Application Ref:	2026/0428			 Ribble Valley Borough Council www.ribblevalley.gov.uk
Date Inspected:	06/08/2026	Site Notice:	EP	
Officer:	EP			
DELEGATED ITEM FILE REPORT:				APPROVAL

Development Description:	Alterations and refurbishment works to the existing dwelling and erection of a single storey extension to the front.
Site Address/Location:	Higher Trapp Barn Trapp Lane Simonstone BB12 7QW

proposed front elevation (NW)
1:50

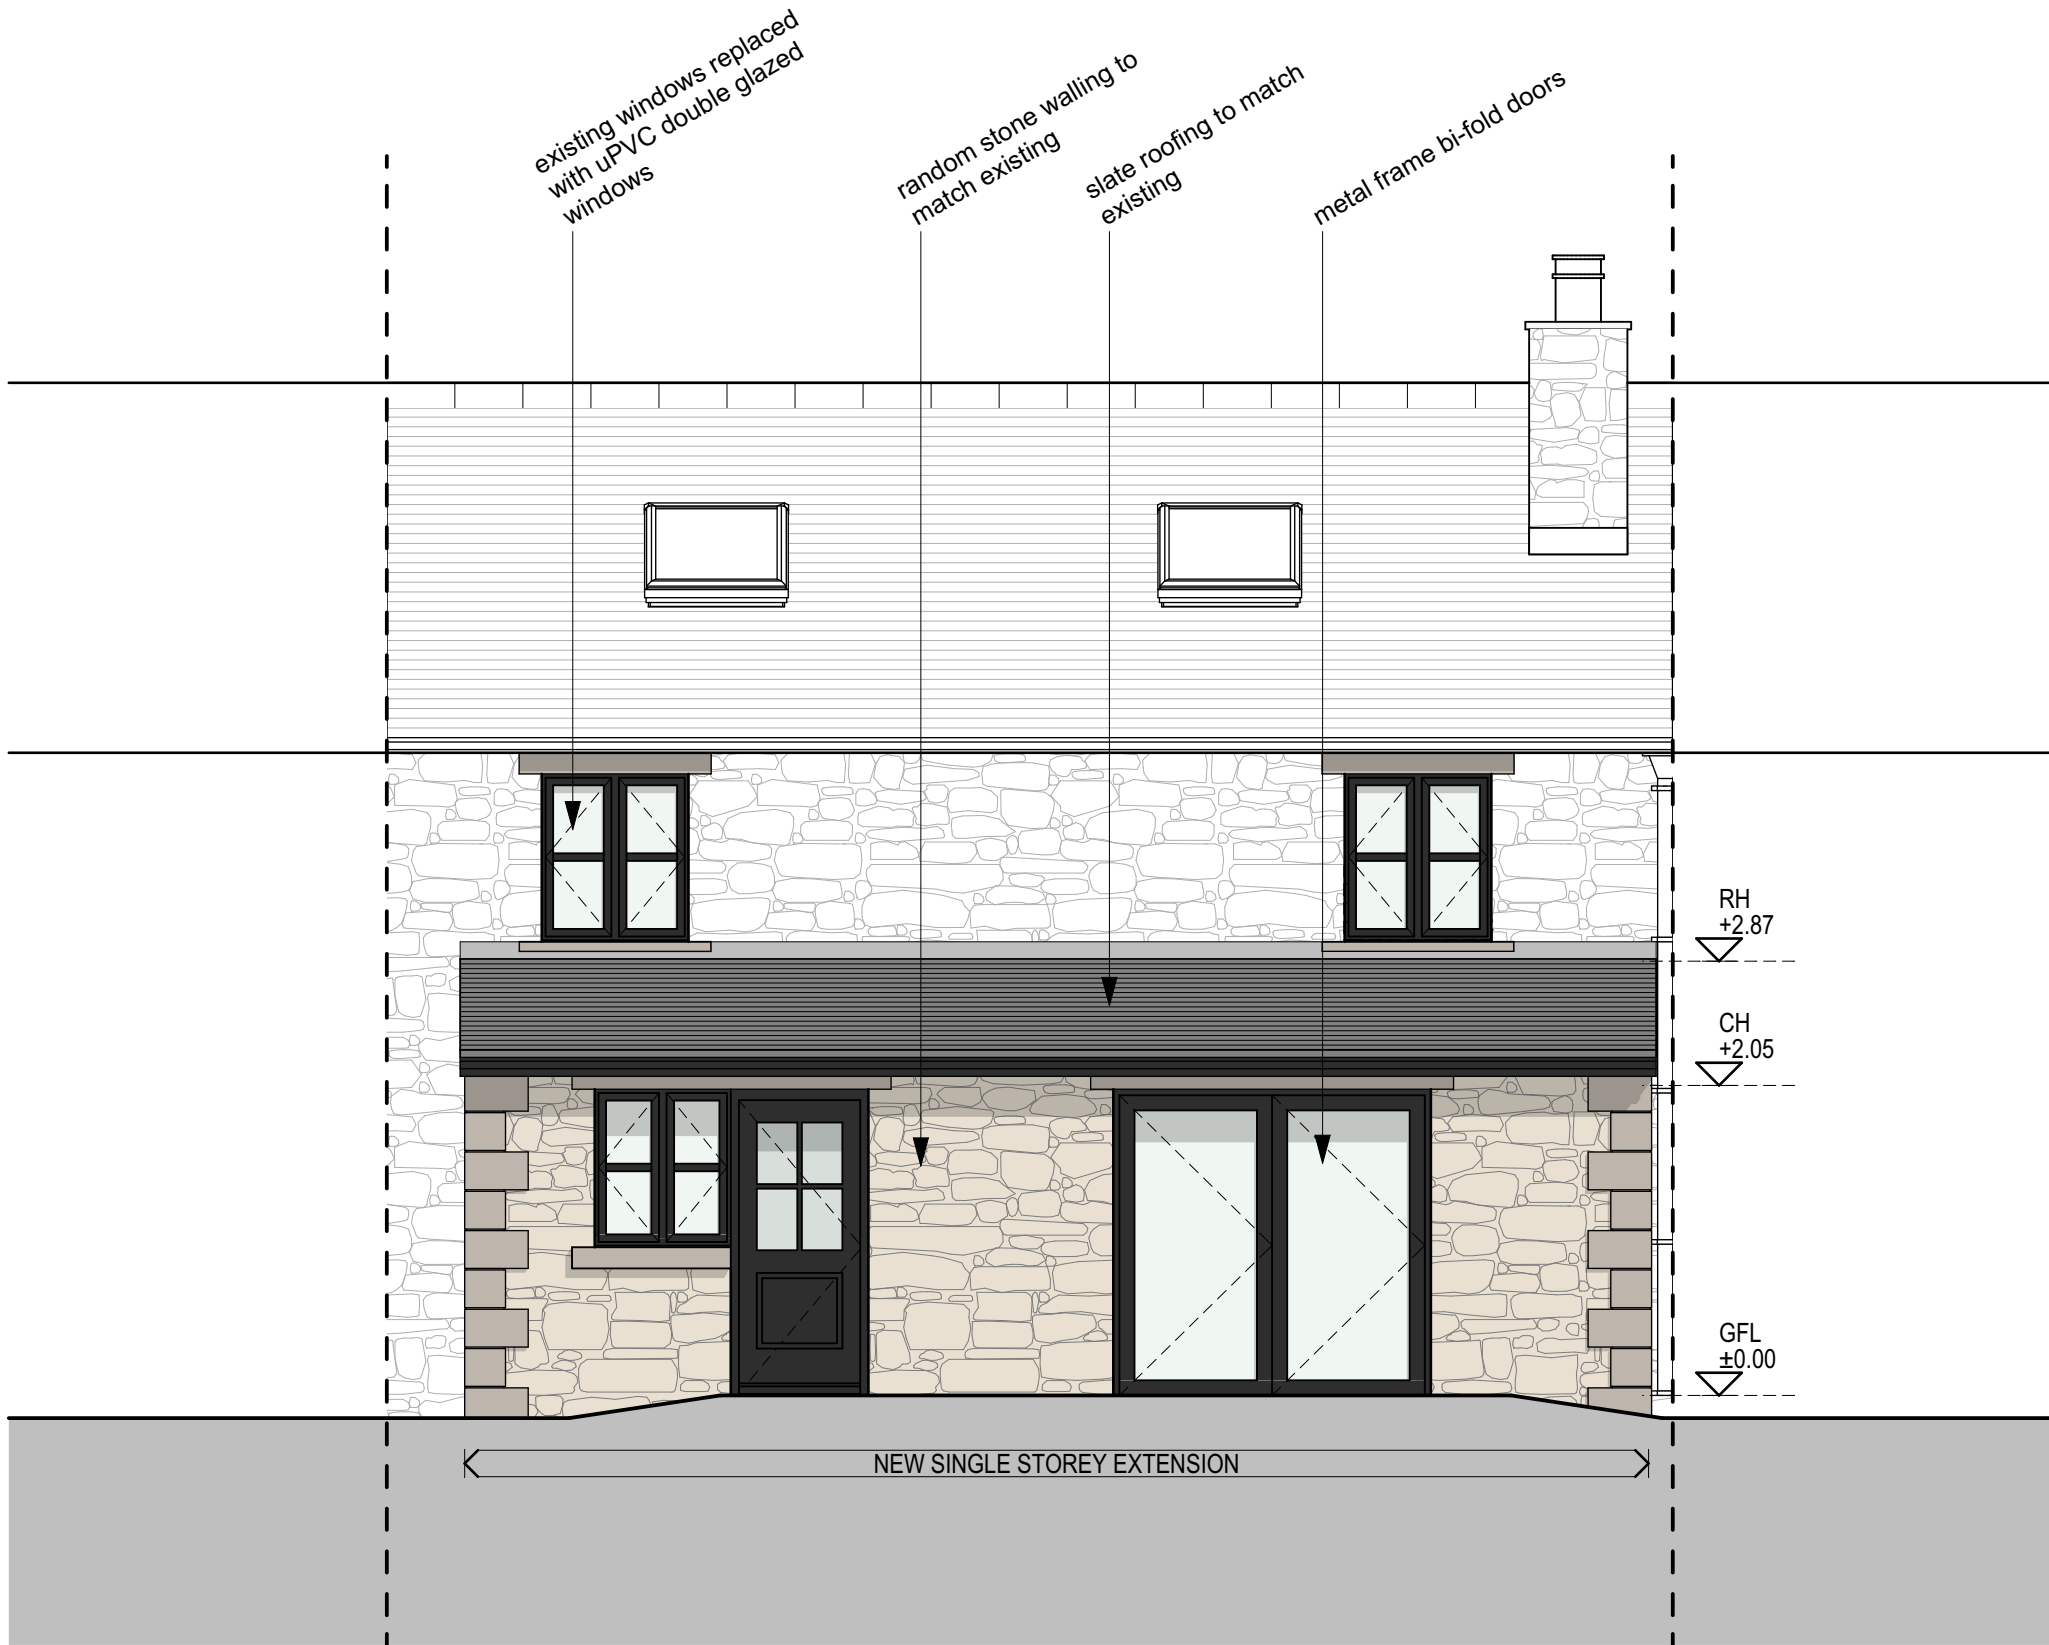
The proposed extension will feature a lean-to roof and has a modest projection of 2.7m, and the extension will be set in from the boundary to the north. As such, despite being to the front, will remain entirely subservient to the application dwelling. The proposed window openings reflect those found on the existing principal elevation, as such, the appearance of the dwelling in this respect will not significantly change.

Whilst single storey extensions across a front elevation would not typically be supported, given the nature of the site with no defined principal elevation, it is not considered to cause harm to the character of the dwelling in this particular case, especially when taking into consideration the screened location of the property.

It is proposed that the large floor to ceiling glazing to the rear of the dwelling will be blocked up. This had already taken place when a site visit was conducted and has been completed in stone to match the existing dwelling. This part of the proposal therefore integrates sufficiently.

proposed ground floor - OPT 2
1:50

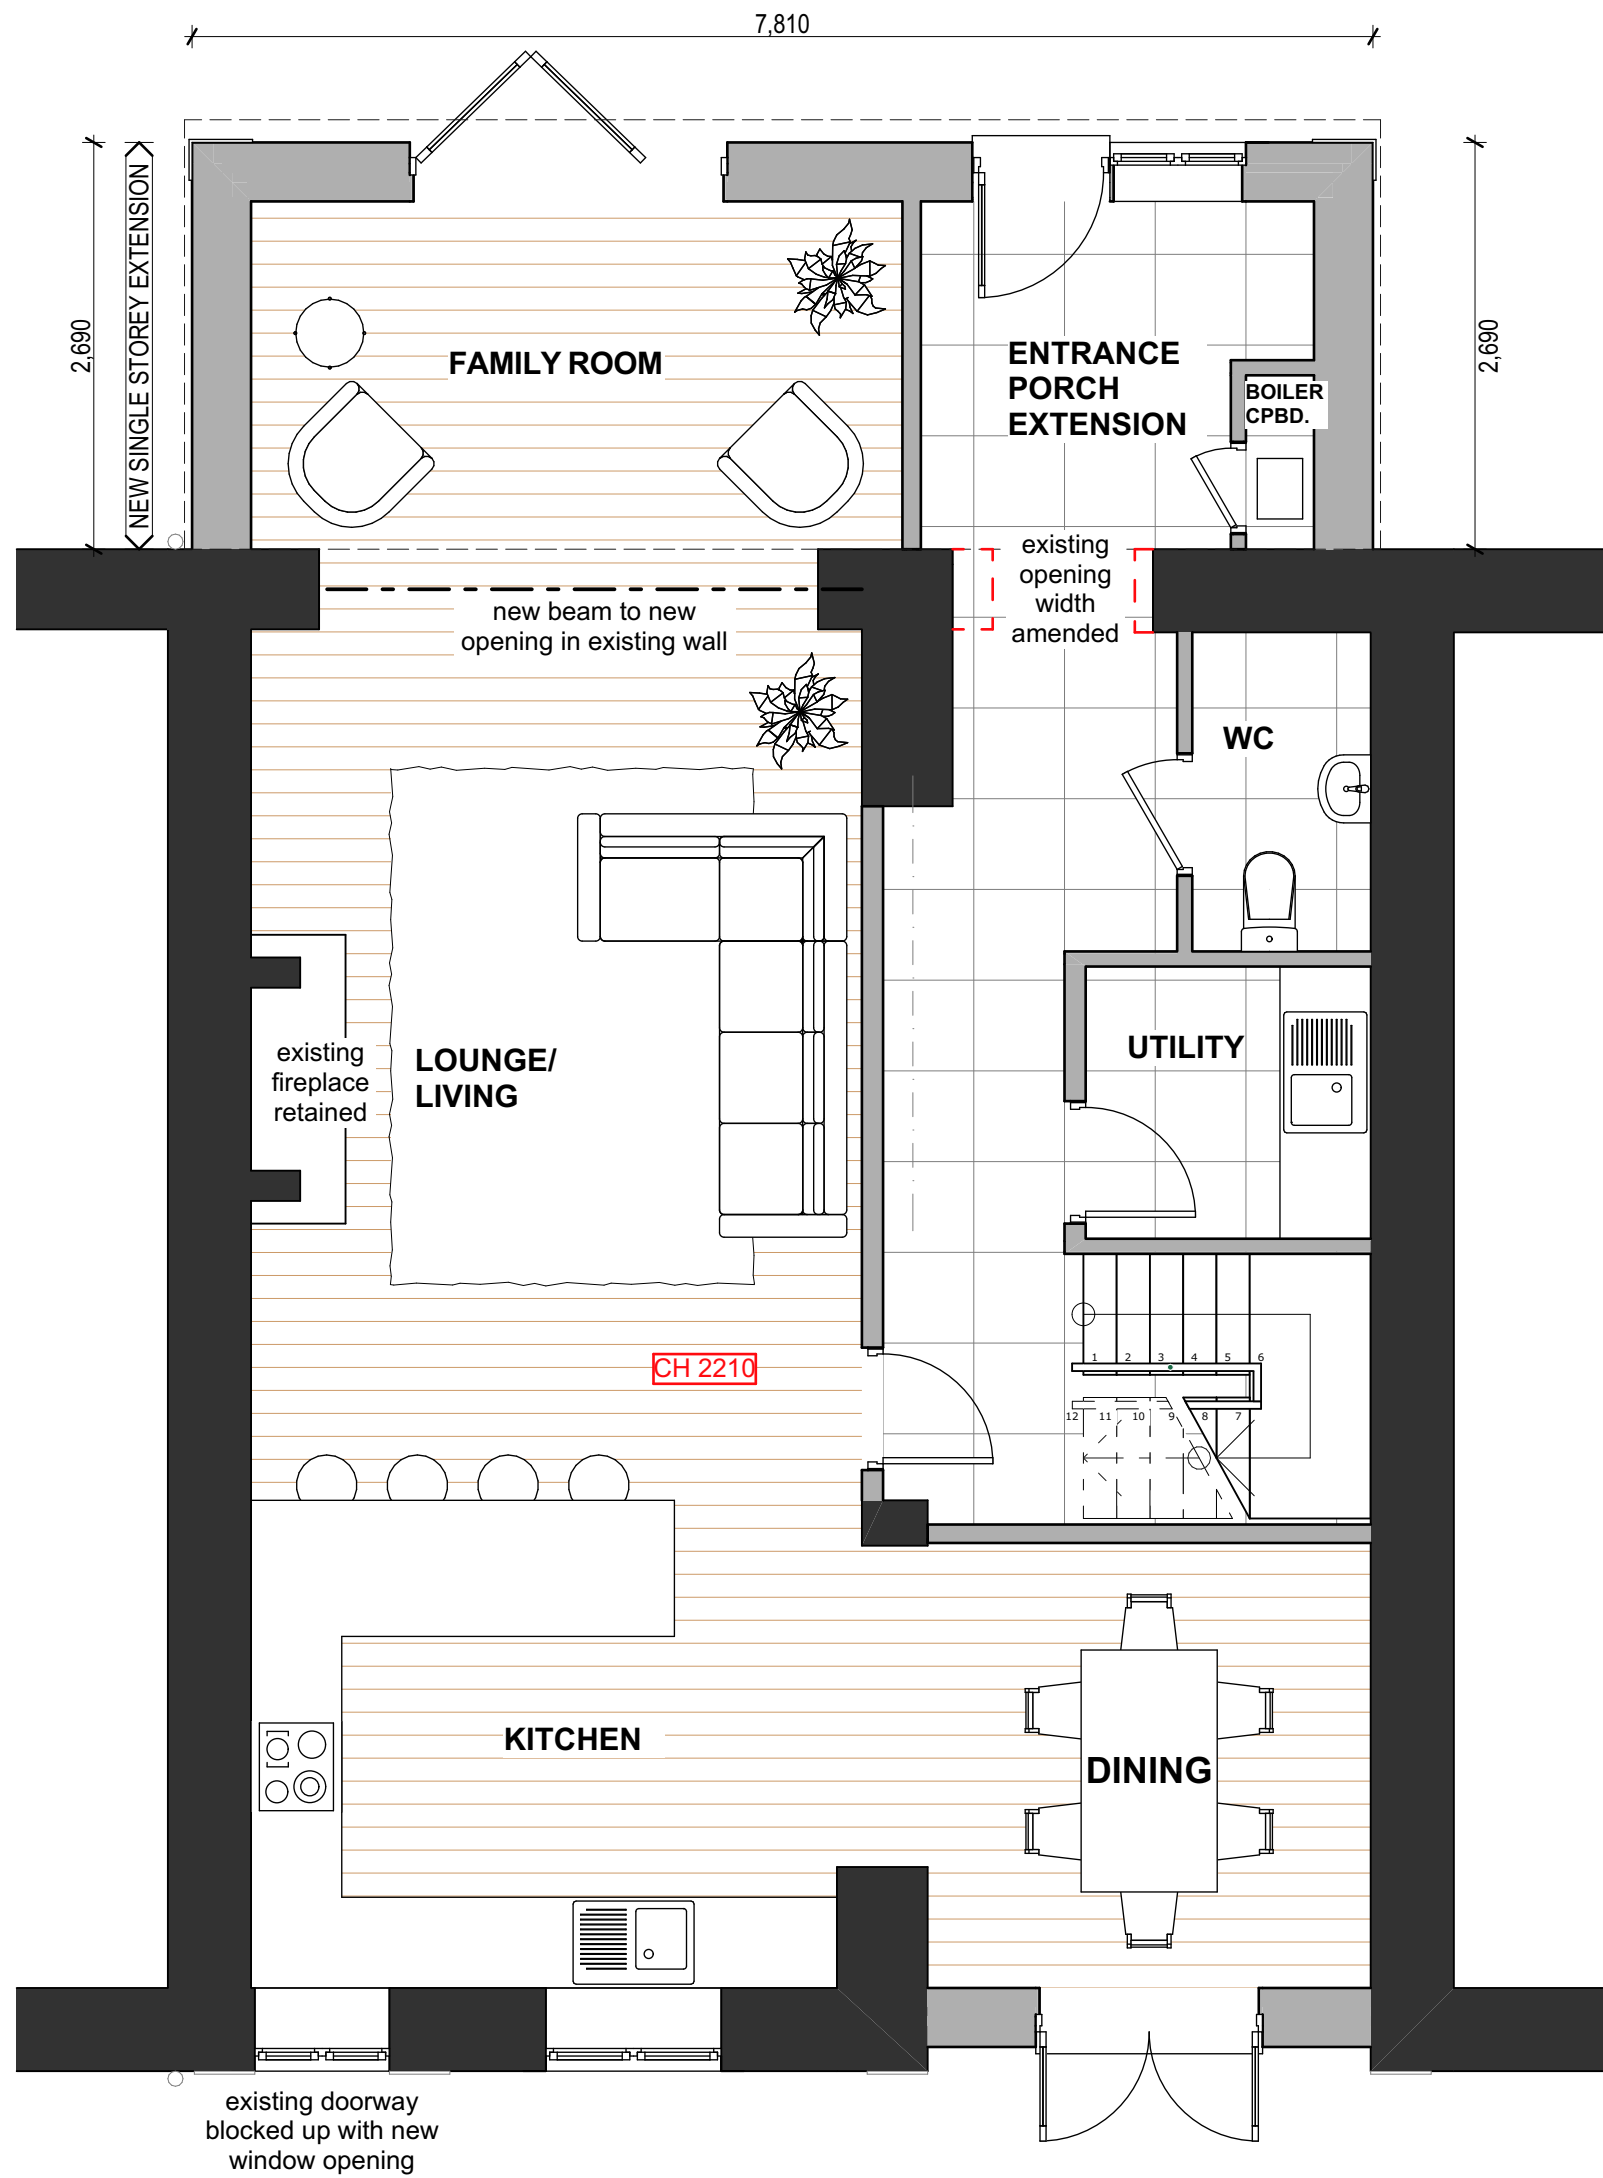
Consent is sought for the construction of a single storey porch extension and alterations to the front and rear fenestrations.

Given the modest single storey nature of the extension projecting just 2.7m, it is not expected that any adverse impact to neighbouring amenity would be inflicted resultant. The proposed window openings provide views solely for the applicant's private curtilage and are in comparable positions to any existing glazing.
